Our Ref: FG/179/17/PL

**Town & Country Planning Act 1990 (as amended)
Town and Country Planning (Development Management Procedure) (England) Order 2015
Application for Planning Permission**

Development Application for variation of Condition No. 2 imposed under FG/180/16/HH to amend the design of the front elevation of the approved extension together with changes to openings on the North, East & West elevations. Resubmission of FG/77/17/PL

Location 11 Telgarth Road Ferring,,

420.04M

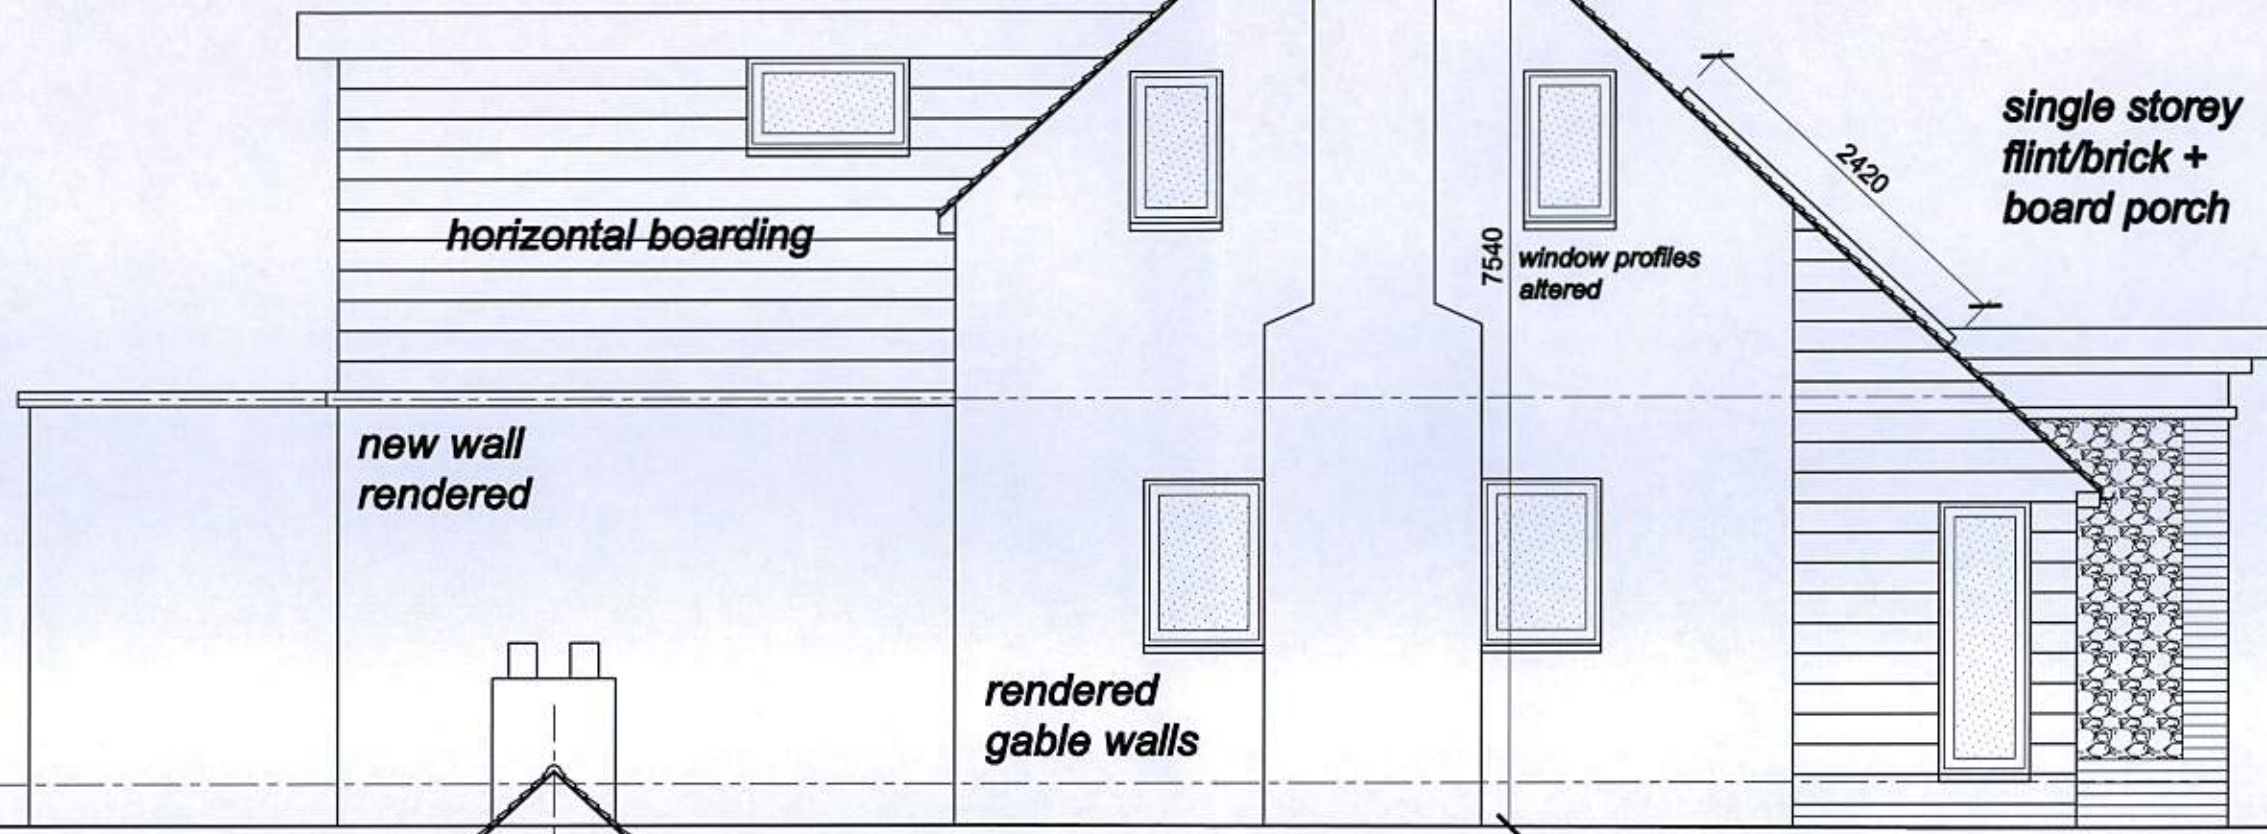
Please confirm if the East and West elevation windows on the first floor 2nd storey extension element are now going to be implemented.
